**KIRKLEES METROPOLITAN COUNCIL
INVESTMENT & REGENERATION SERVICE**

DELEGATED DECISION TO DETERMINE PLANNING APPLICATIONS

Reference No:	2022/62/91839/W
Site Address:	7, Gatesgarth Crescent, Lindley, Huddersfield, HD3 3LG
Description:	Erection of two storey side extension
Recommending Officer:	Tom Hunt

Officer Report

Drg. no.	Rev.
117-22-PL02	B

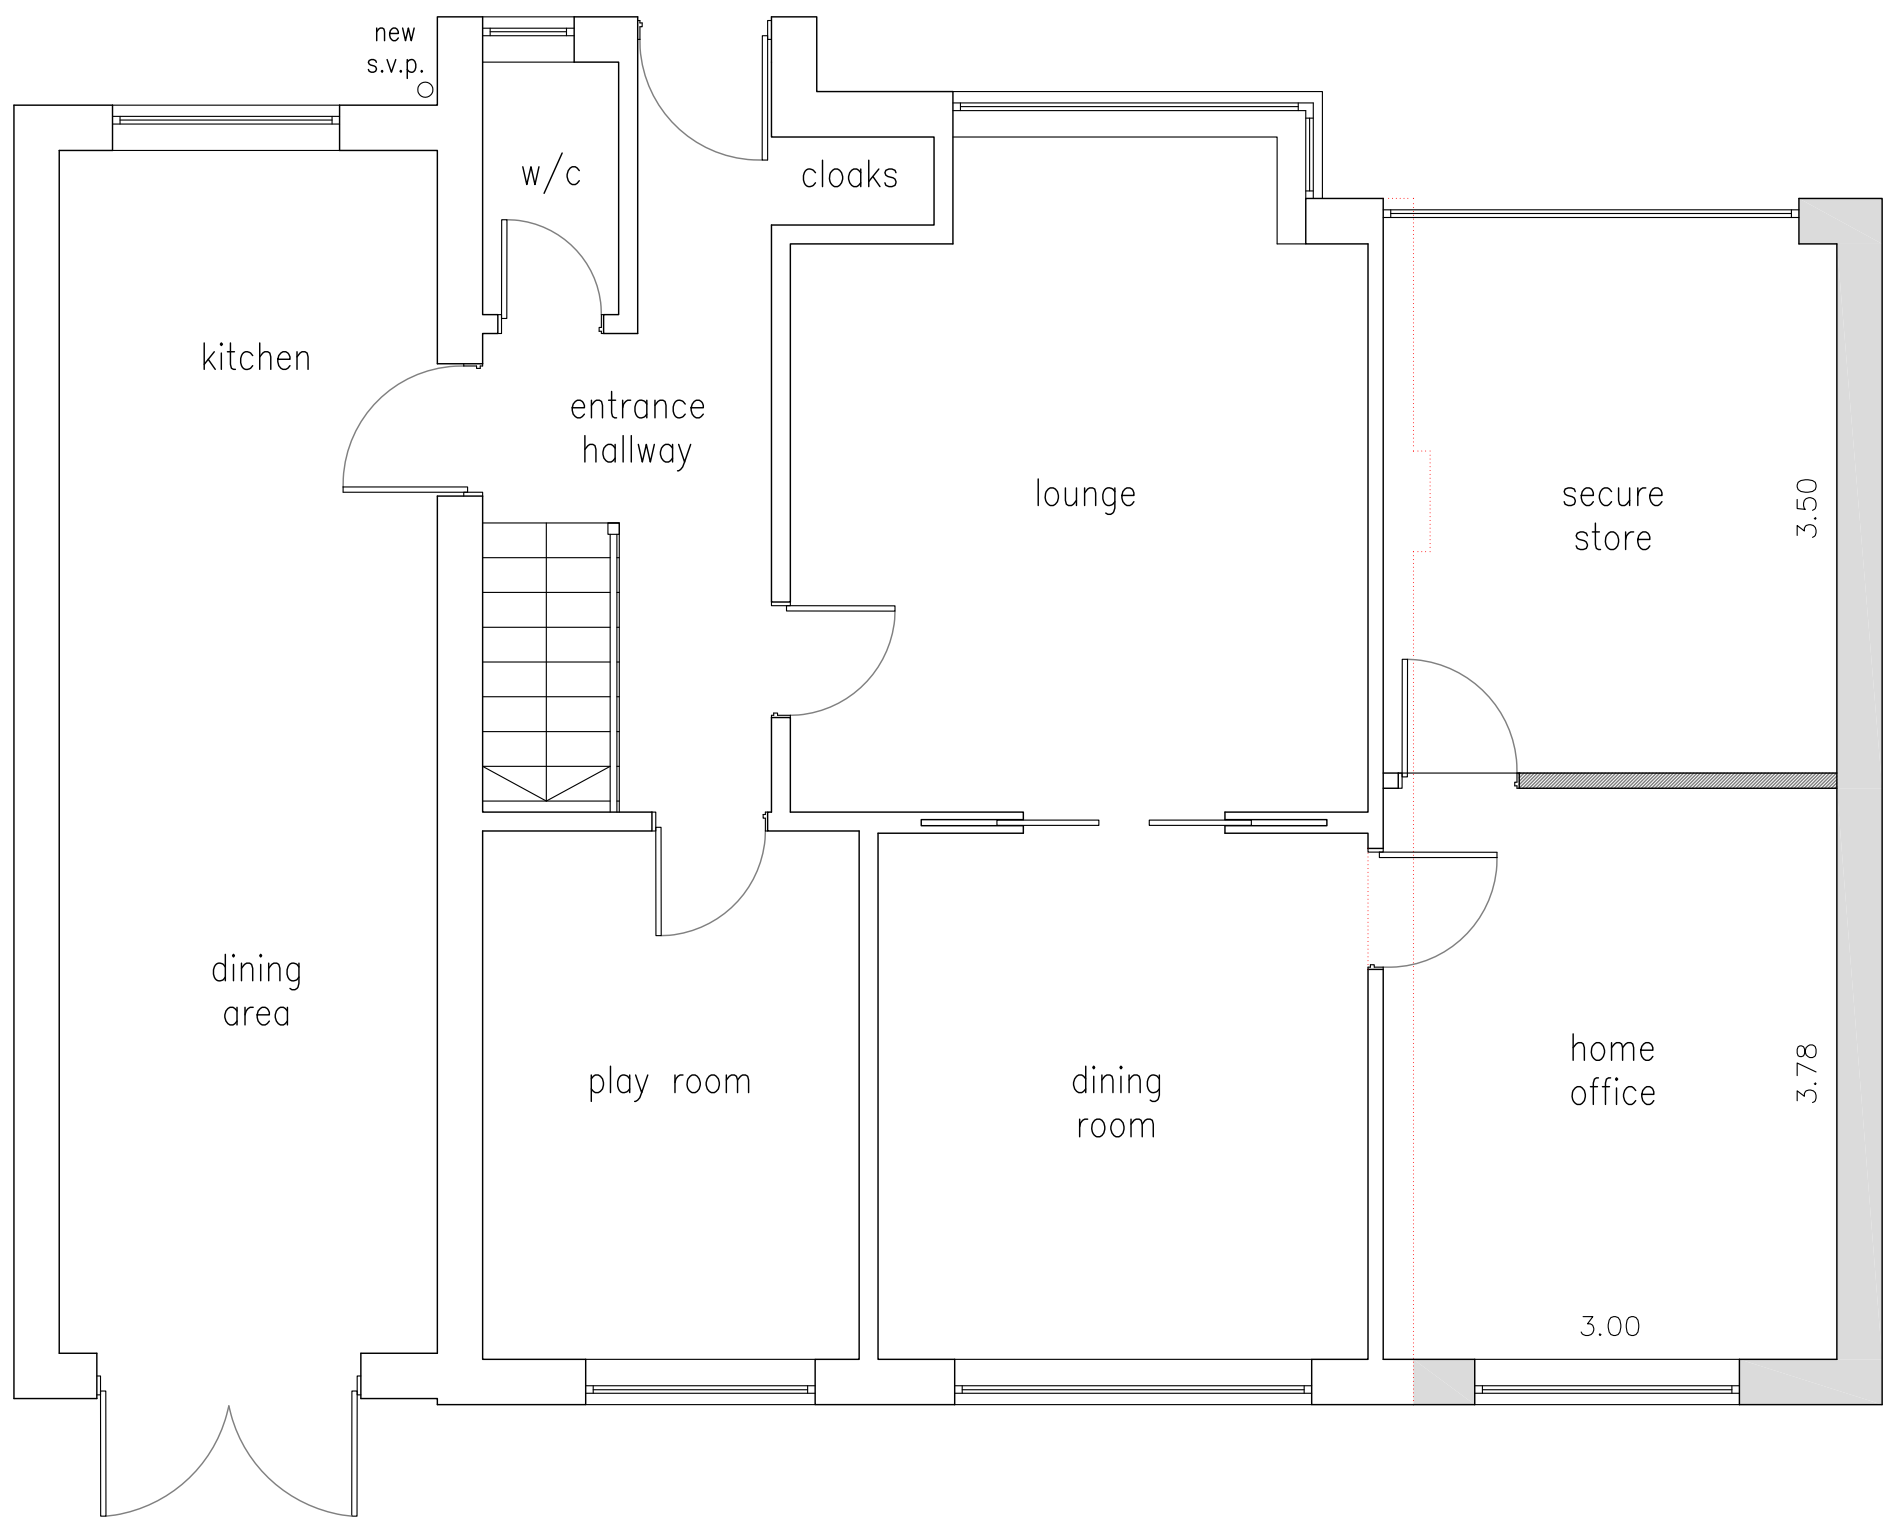
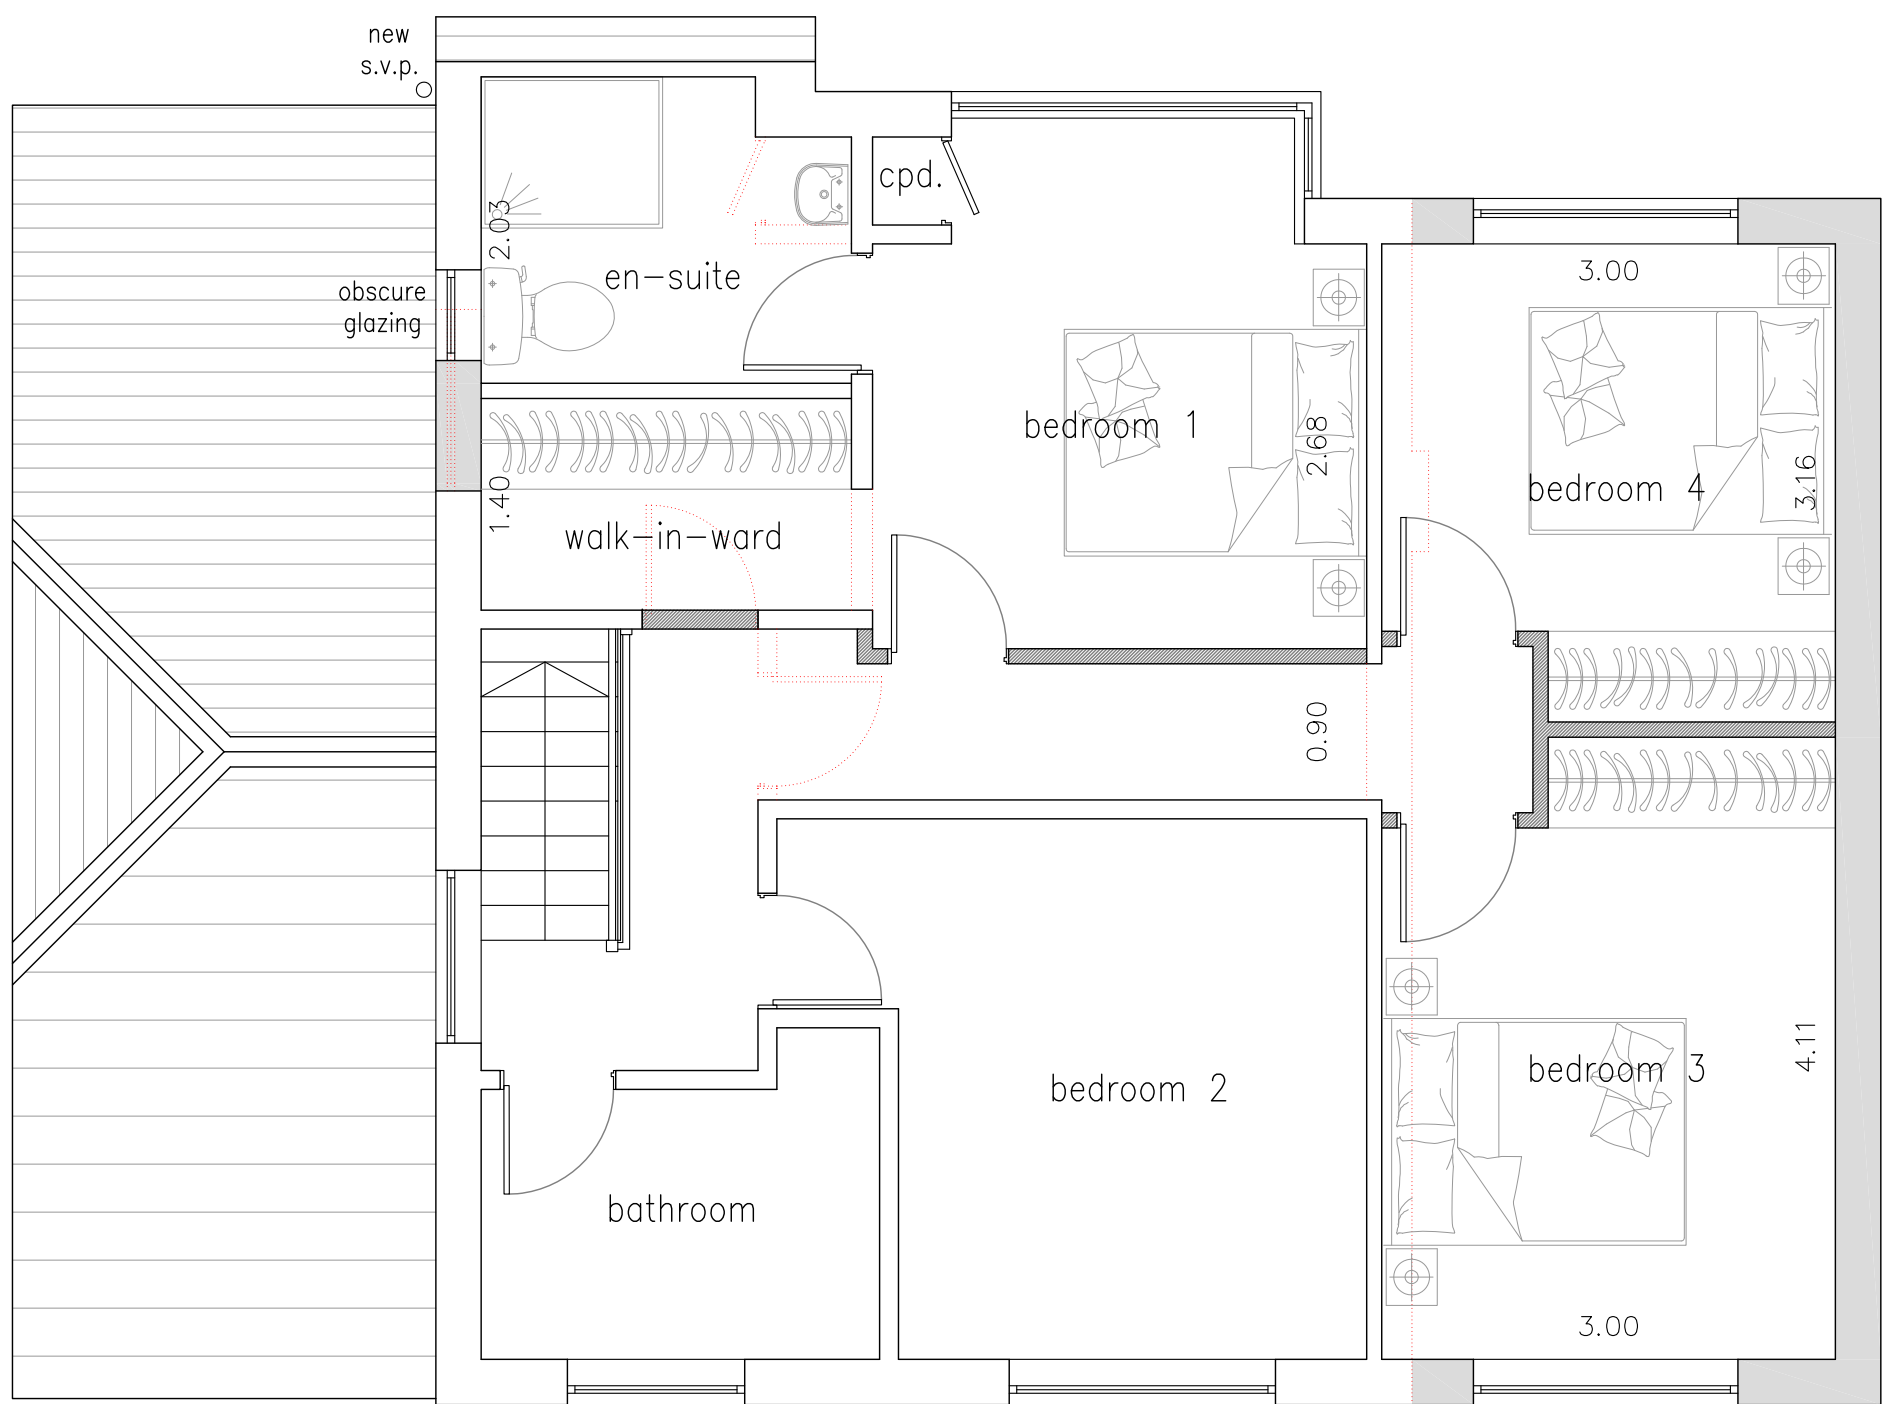
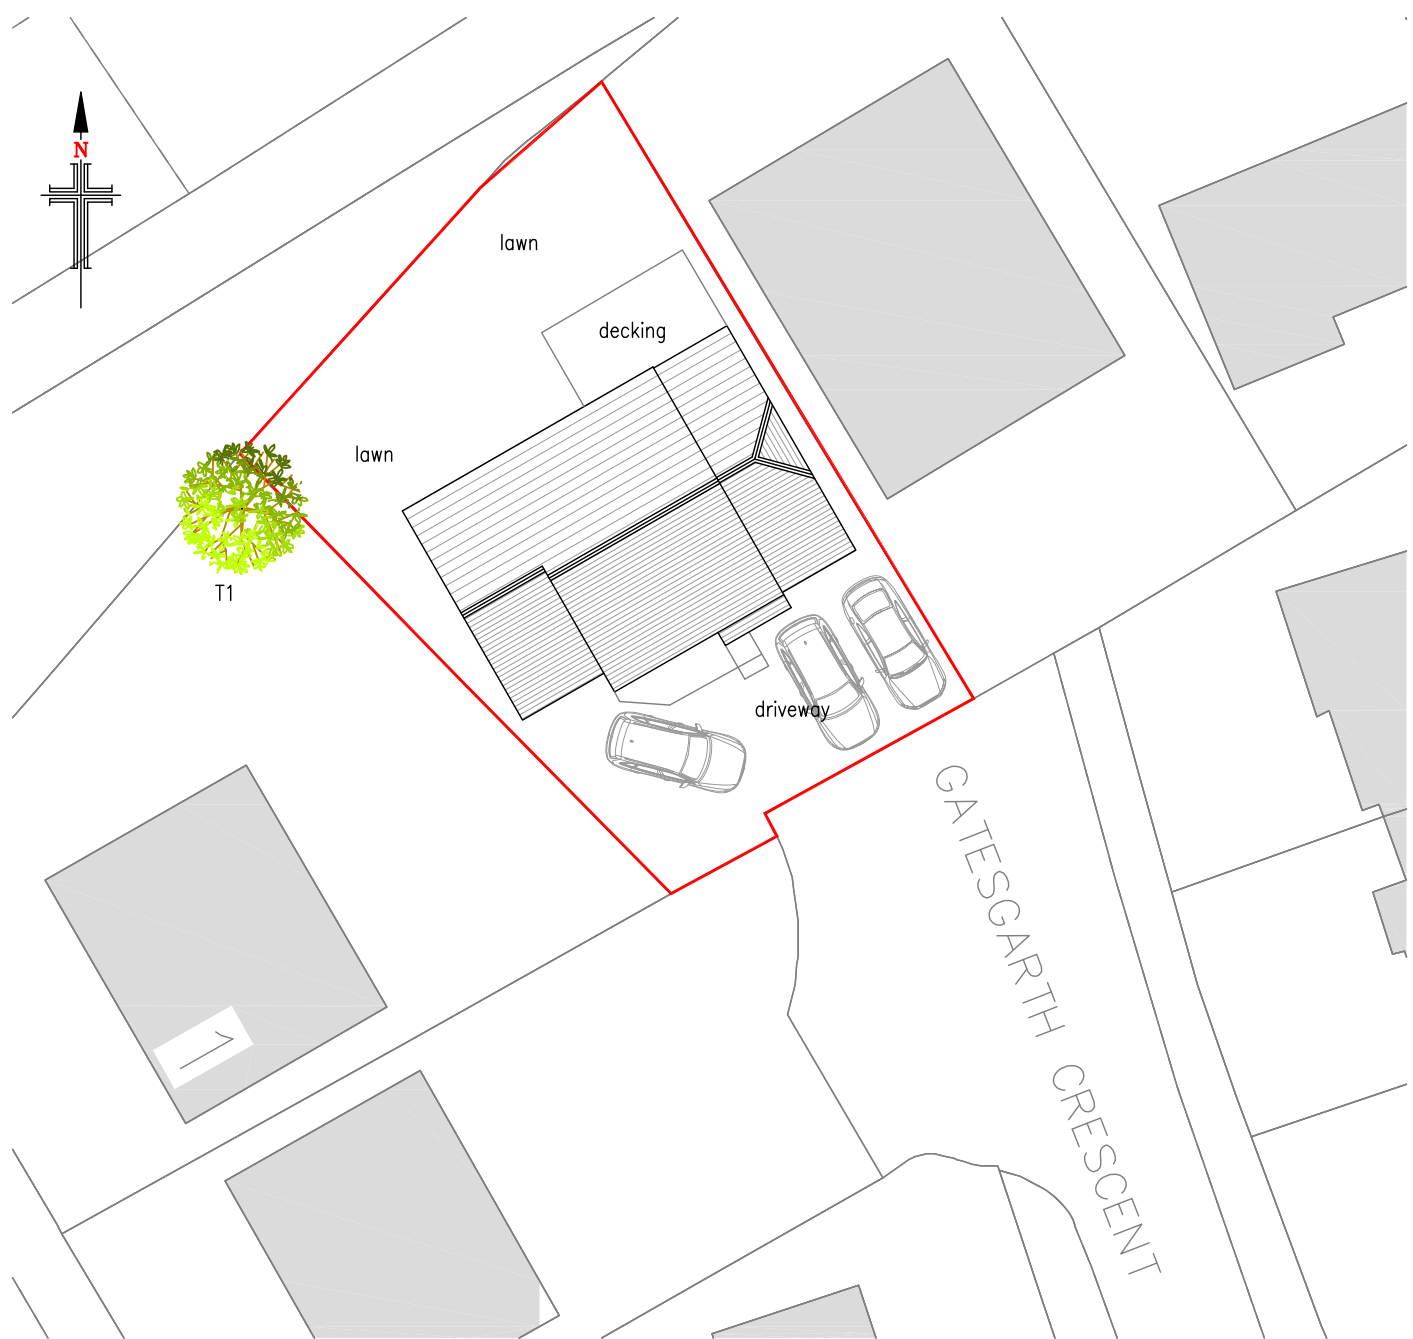
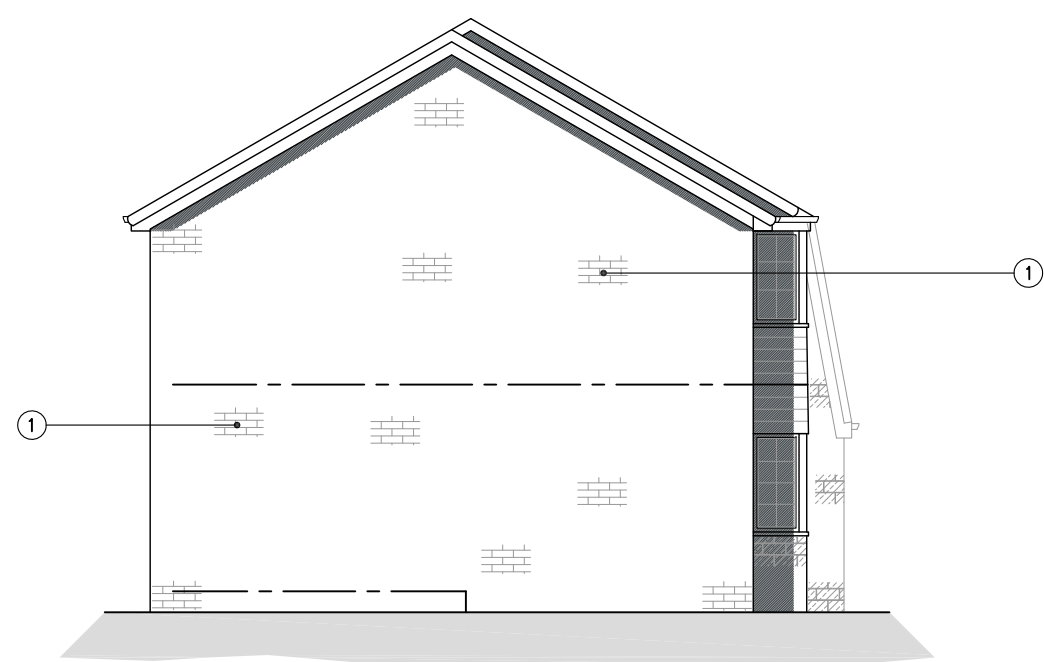
The case officer considered the application on review and requested amended plans to have a greater set back from the main body of the

dwellinghouse to meet House Extension and Alterations SPD guidance so that it was a subservient addition
